GEOTECH
CONSULTANTS, INC.

Memorandum

RE: Backyard Retaining Wall Revision
9785 SE 41st Street, Mercer Island

A. SITE PLAN

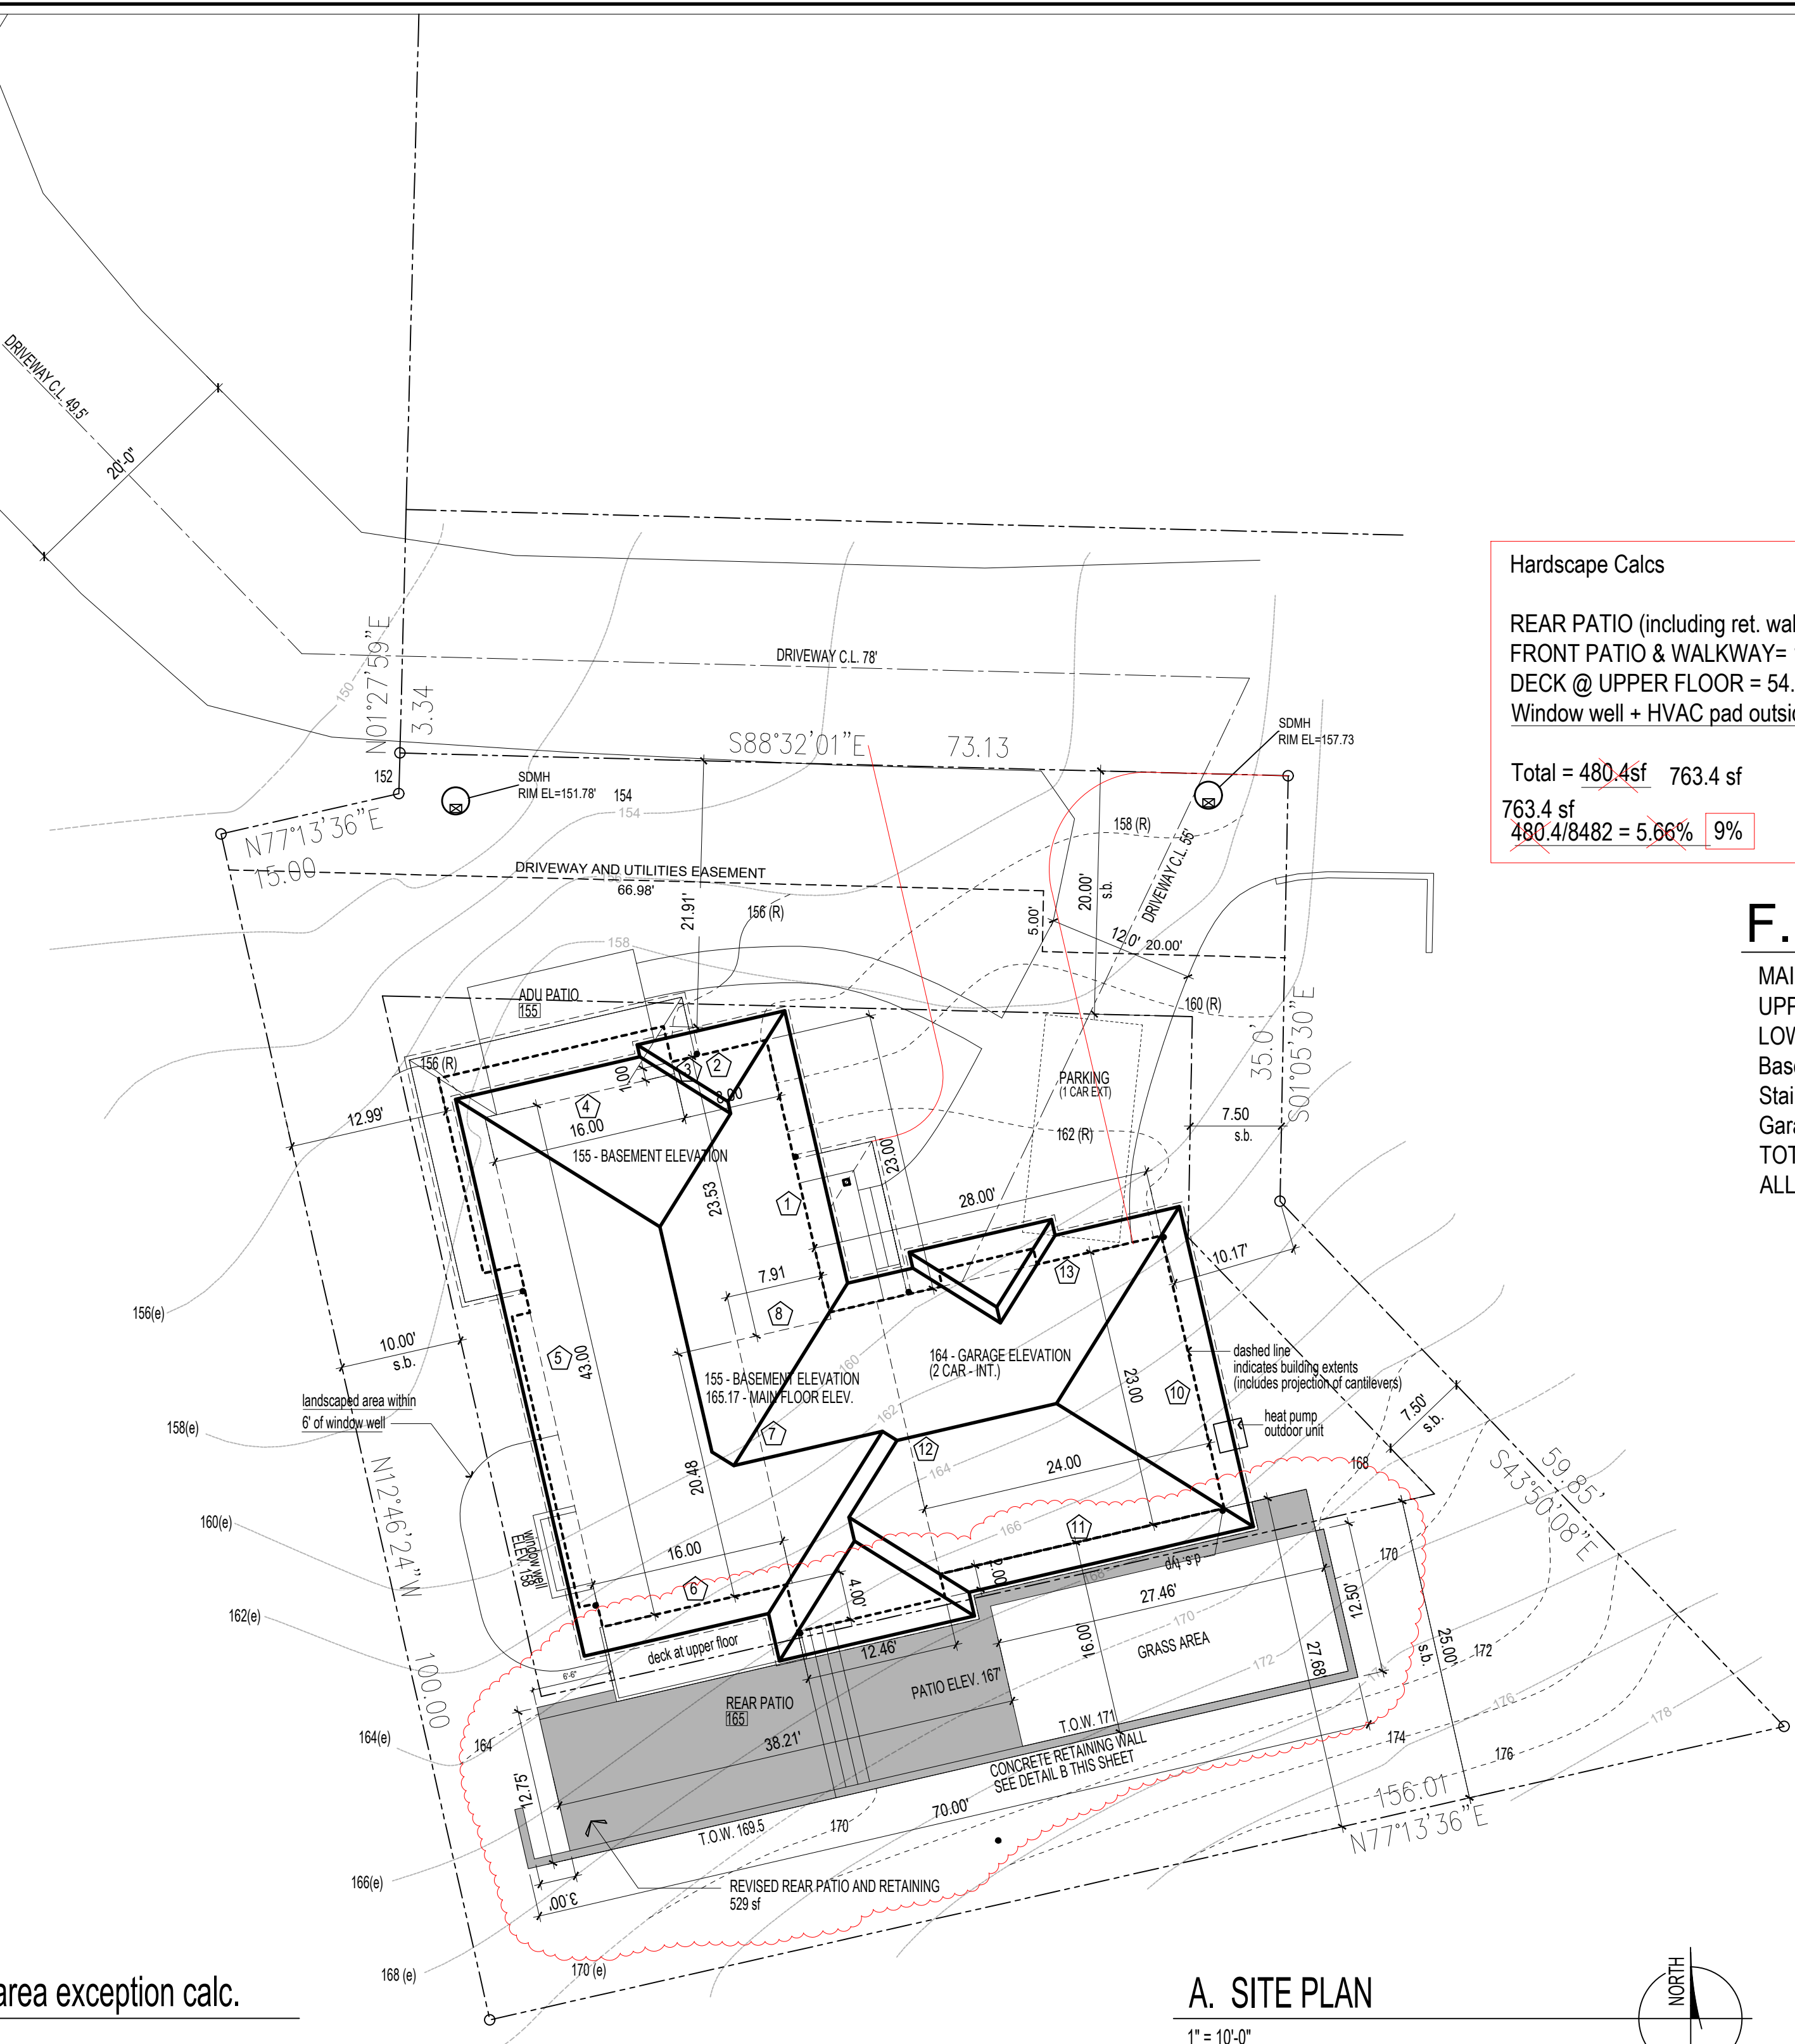
We visited the site on April 16, 2021 to observe the excavation for the backyard retaining wall along the southern side of the property. Our comments regarding the cuts are included in the referenced field report. The client has revised the site plan with a new concrete retaining wall. The revised site plan (Sheet 1a) by Centerline Design is dated May 11, 2021 and the retaining wall design by Forsman Engineering dated May 10, 2021 incorporates our recommendations for the sloped (2:1 (H:V)) backfill.

We reviewed the referenced plans above. In our judgment, the plans conform to the recommendations in our geotechnical engineering report and daily field report. If our recommendations are satisfied during construction and use of the project, the proposed project will not increase the potential for soil movement. The areas disturbed by construction will be stabilized and should remain stable, subject to the conditions of our geotechnical engineering report.
